Review Response

Project: Mak Remodel – Mercer Island
Site Address 6521 80th Avenue S.E.
Mercer Island, Wa 98040

Permit #(s) Building Permit #2204-166

RE: Response to Review/Screening comments dated 5-26-22

ROOF LAYOUT PLAN

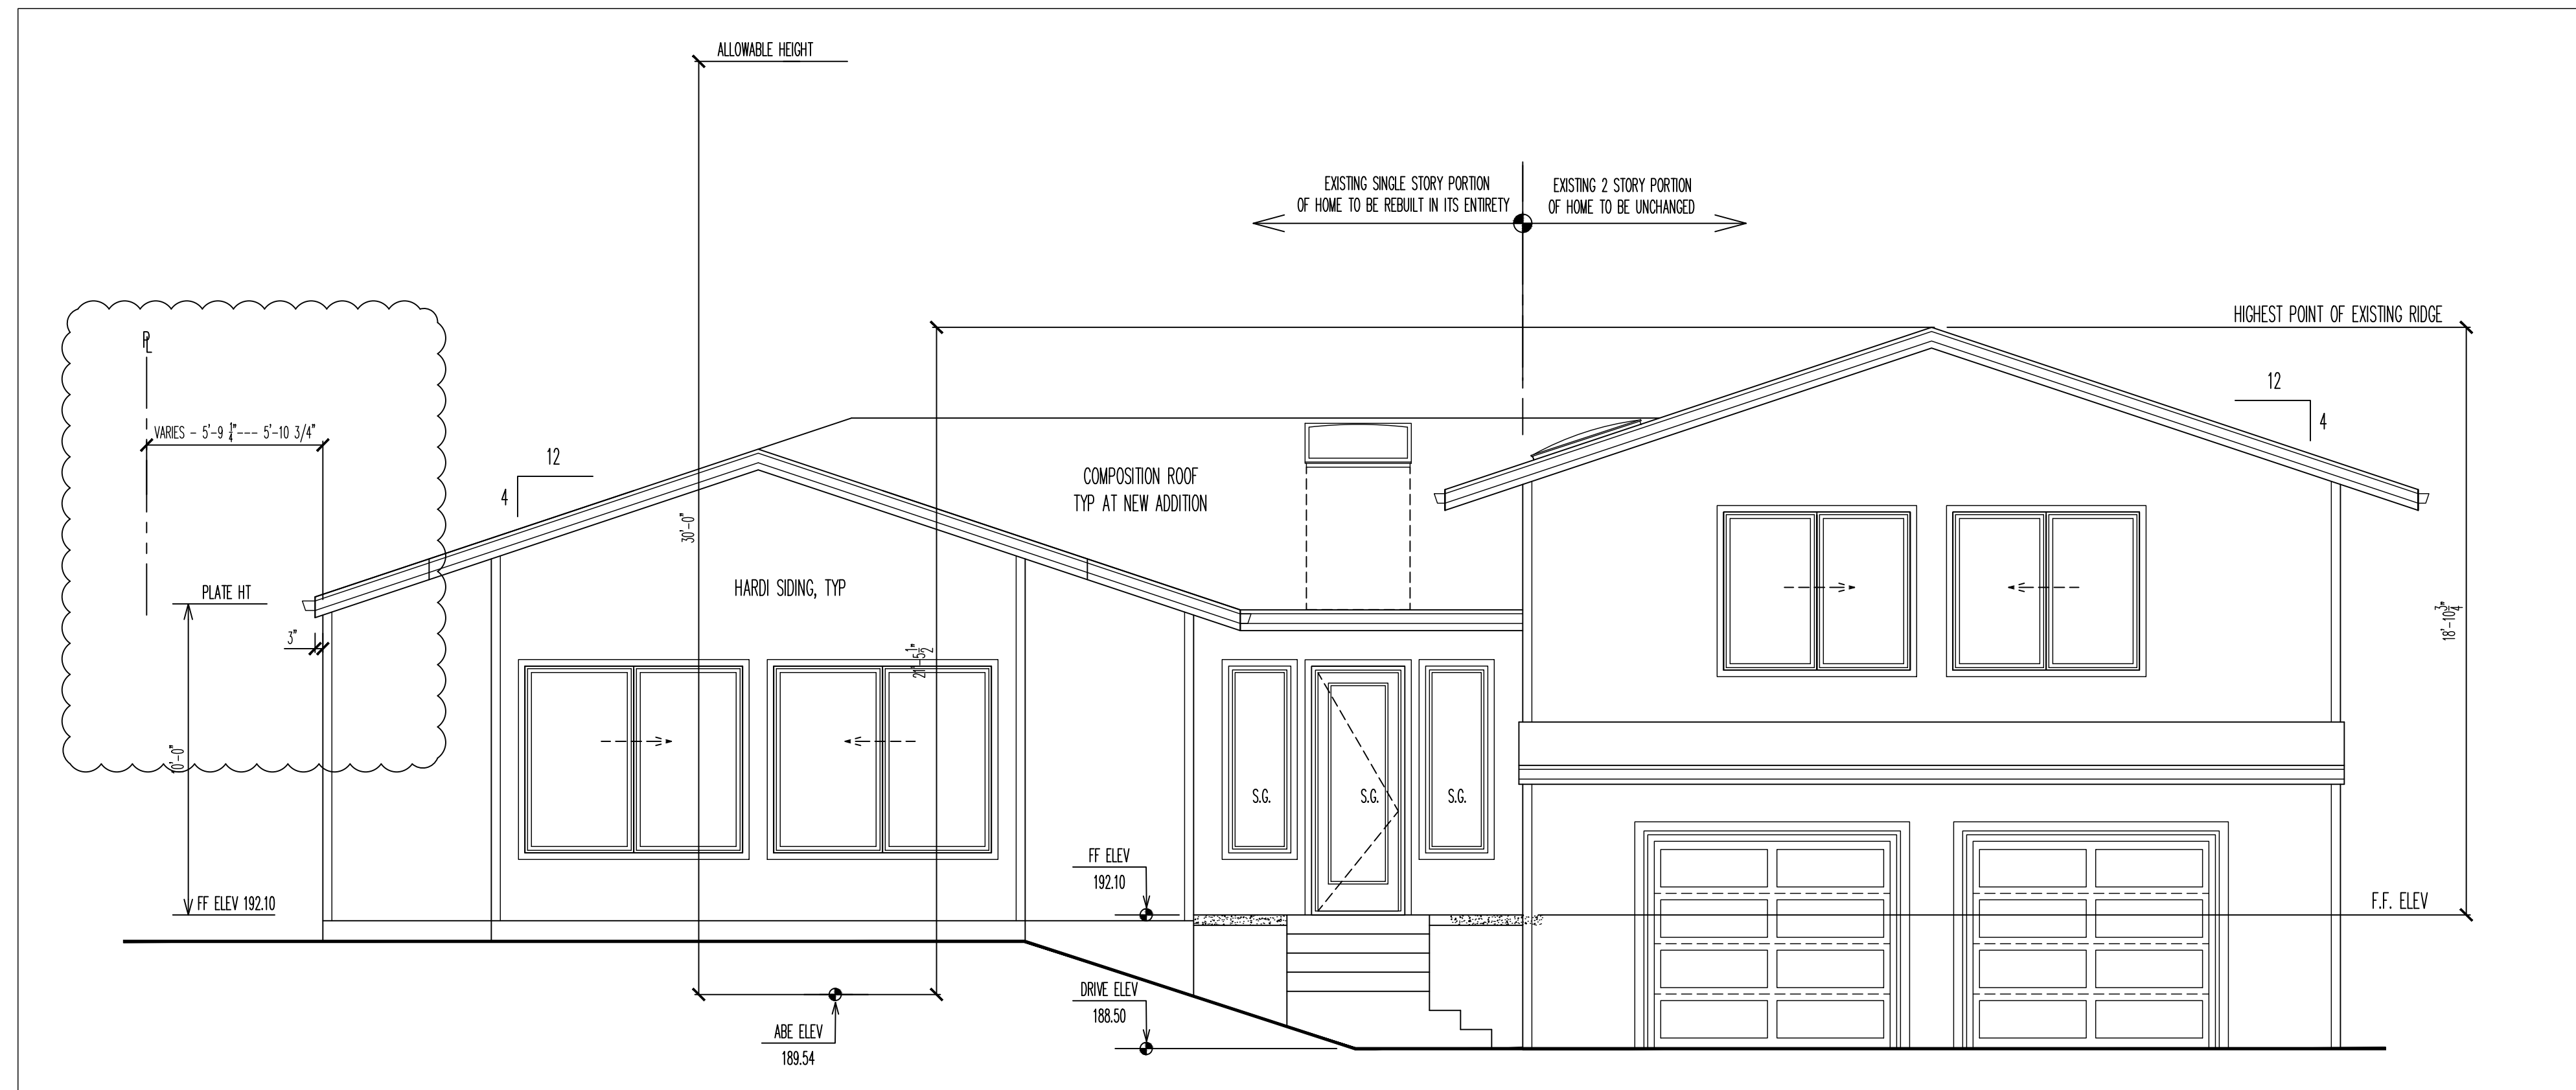
1. Site Plan ST1 Calculations have been updated in their entirety. We reduced the area of the building slightly and shifted the Southern Wall North, in order to provide overhangs/gutters that do not intrude into 5' sideyard setback. Roof Plan also updated to show new overhangs.

EXTERIOR ELEVATIONS

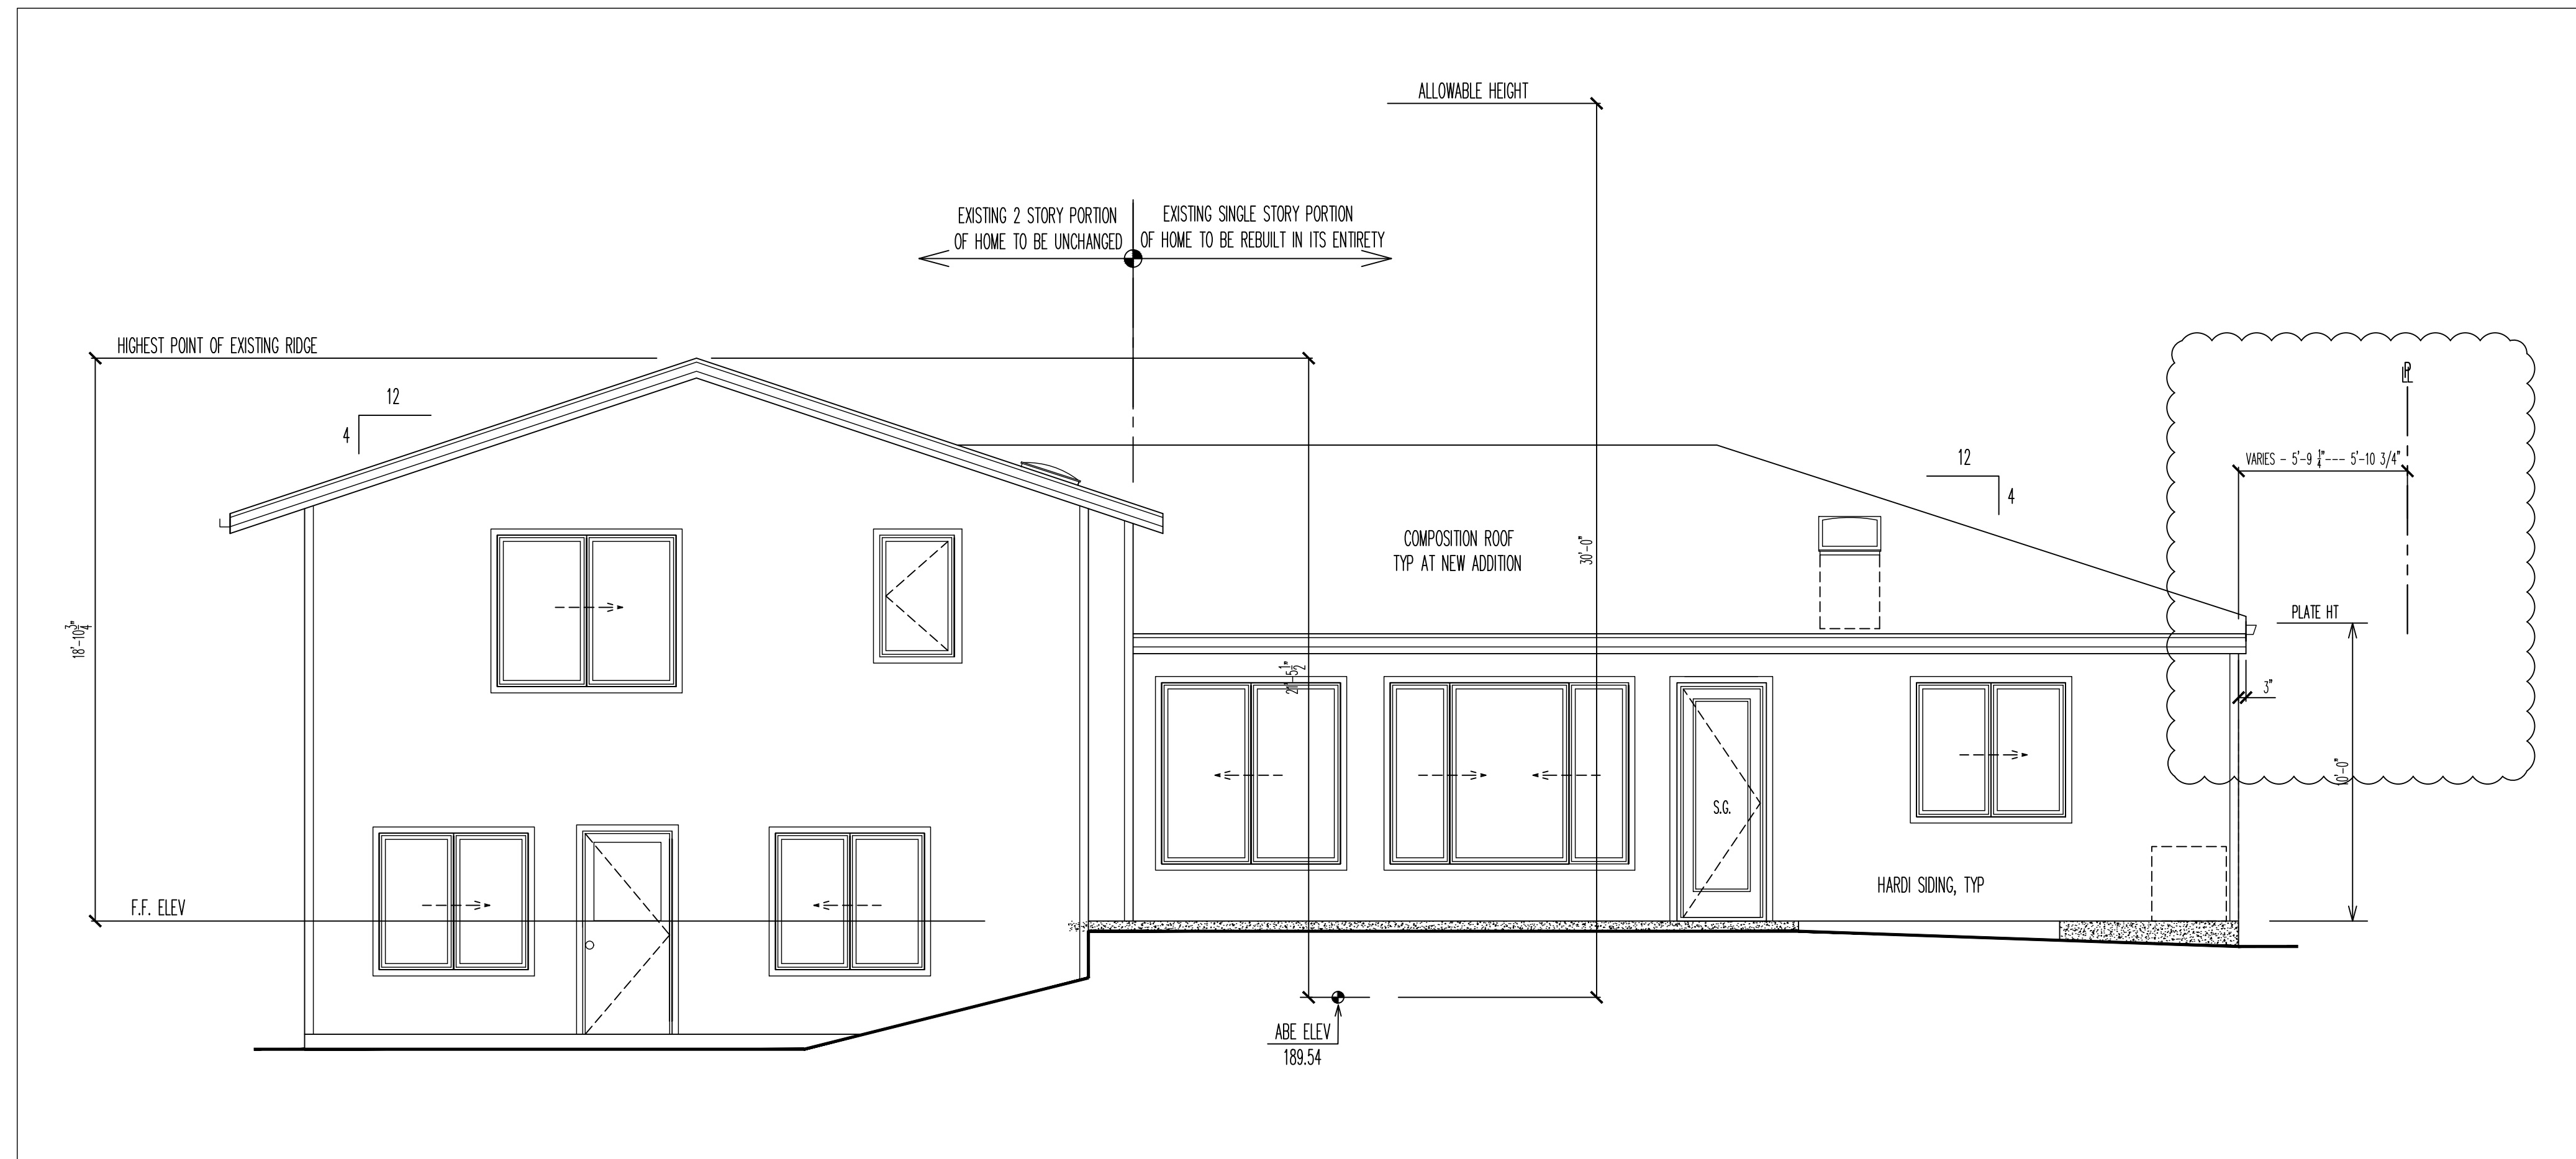
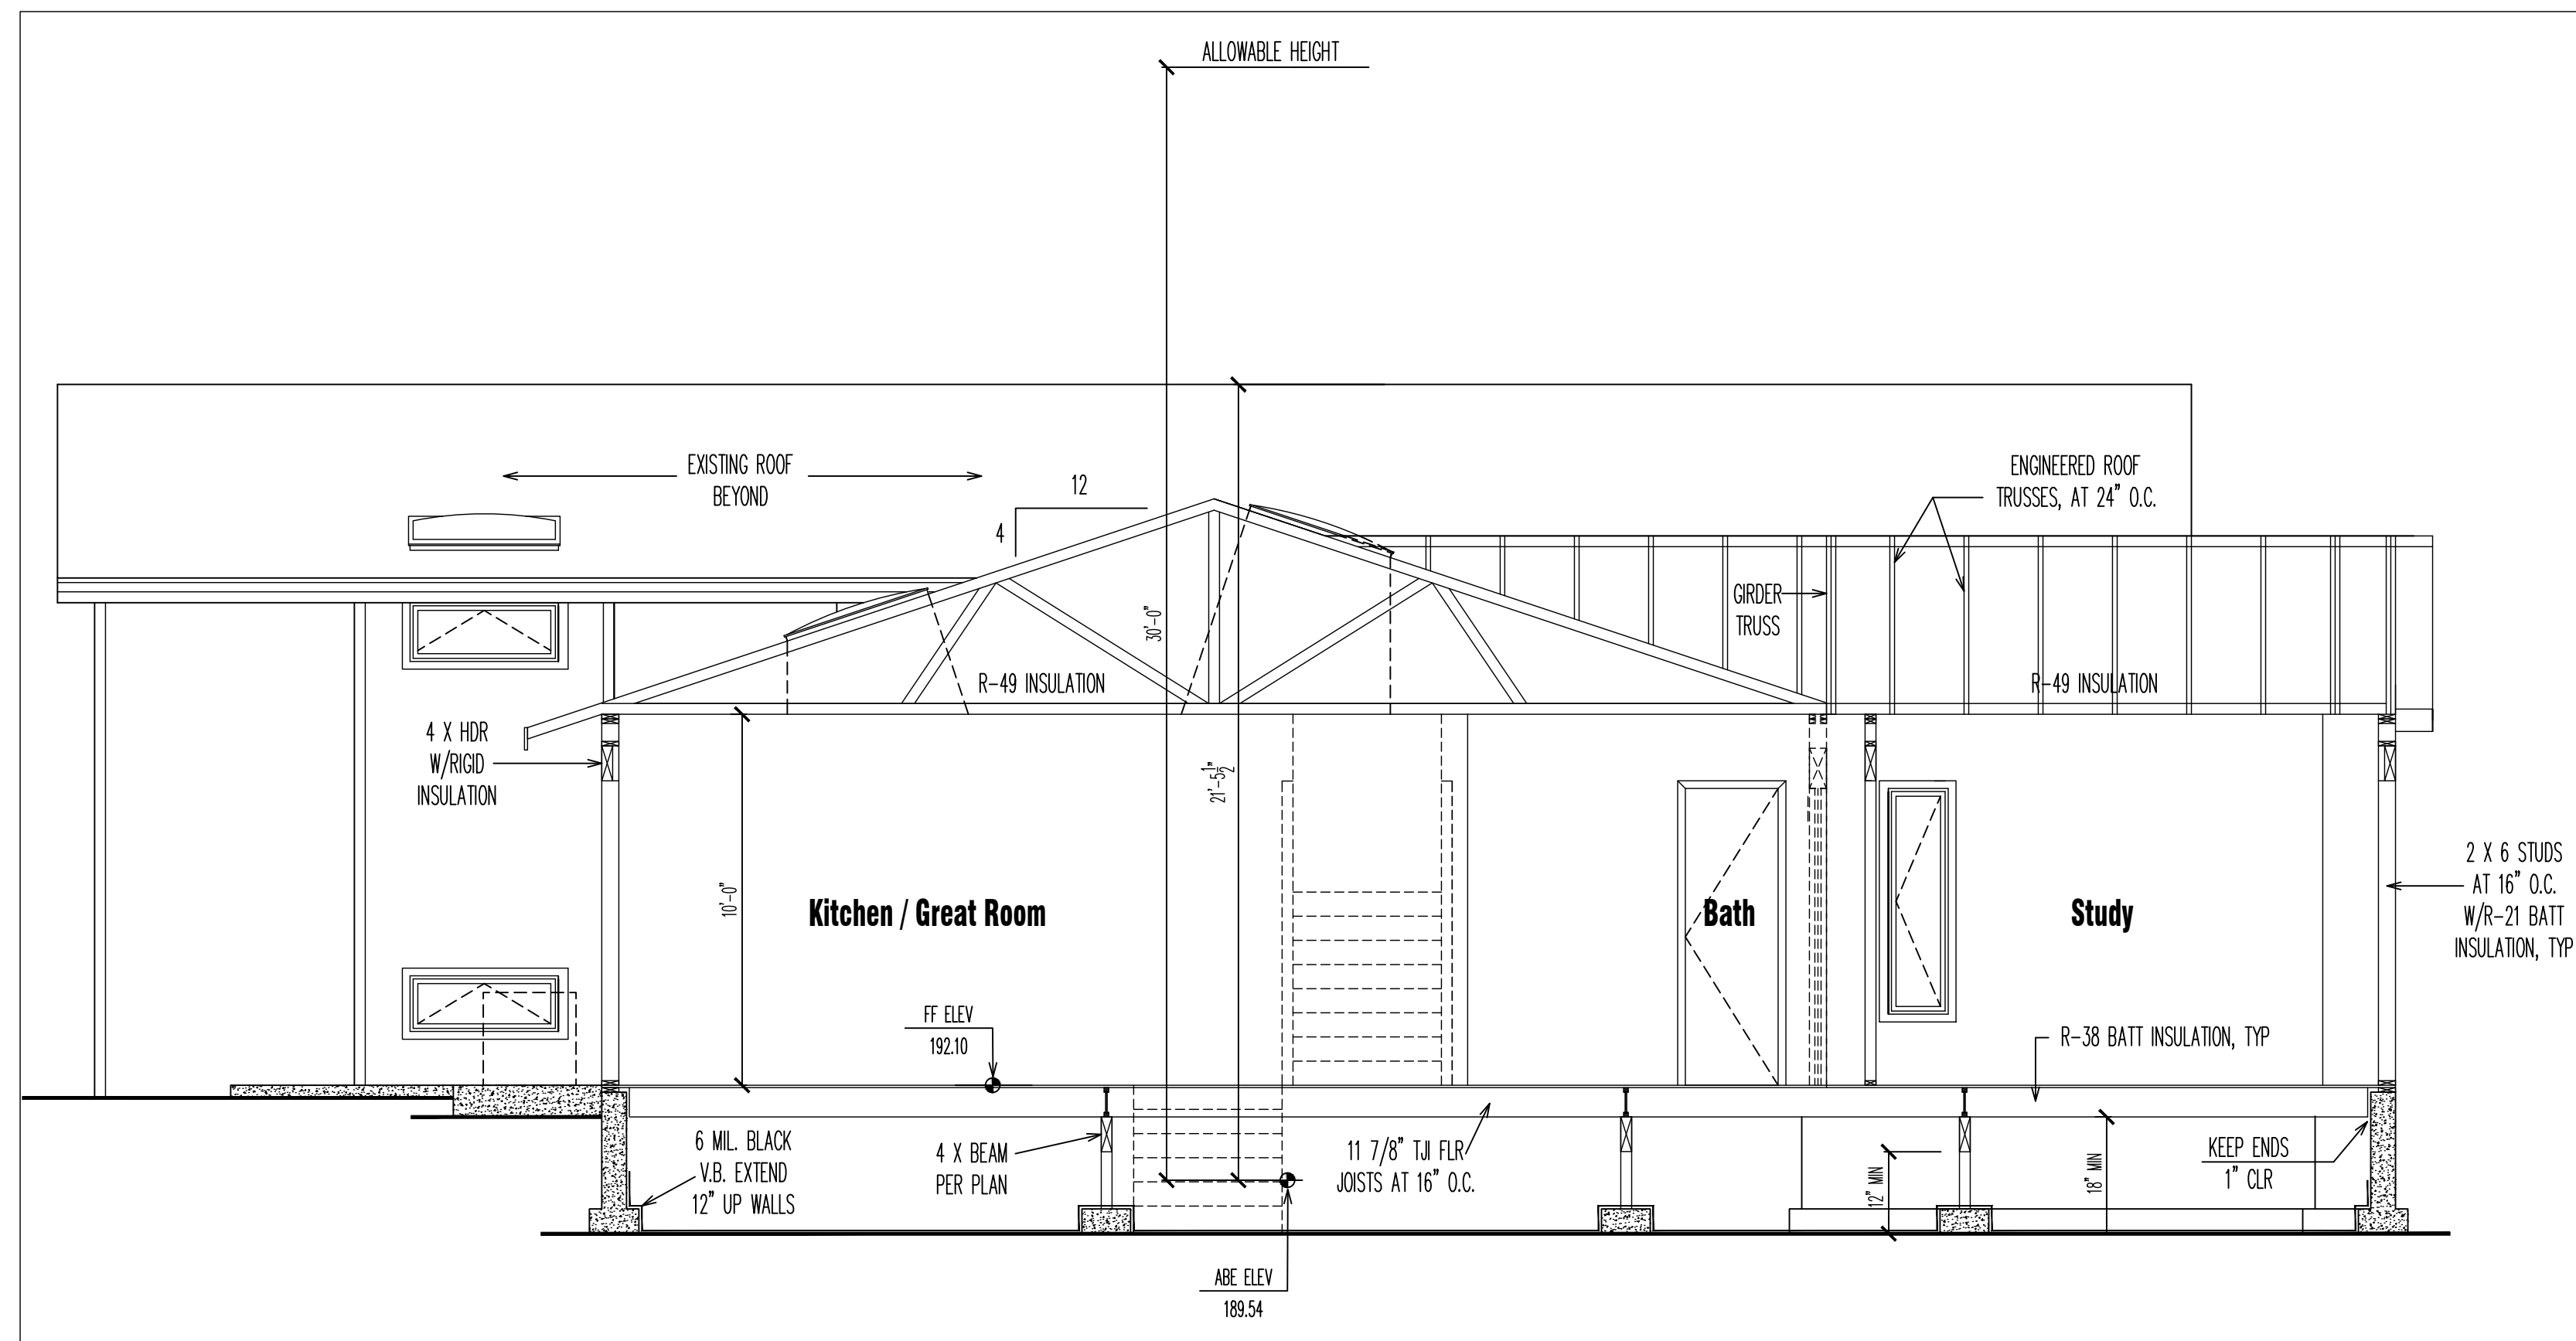
1. PREVIOUSLY ADDRESSED COMMENT: North Elevation is now included on Sheet #A5.
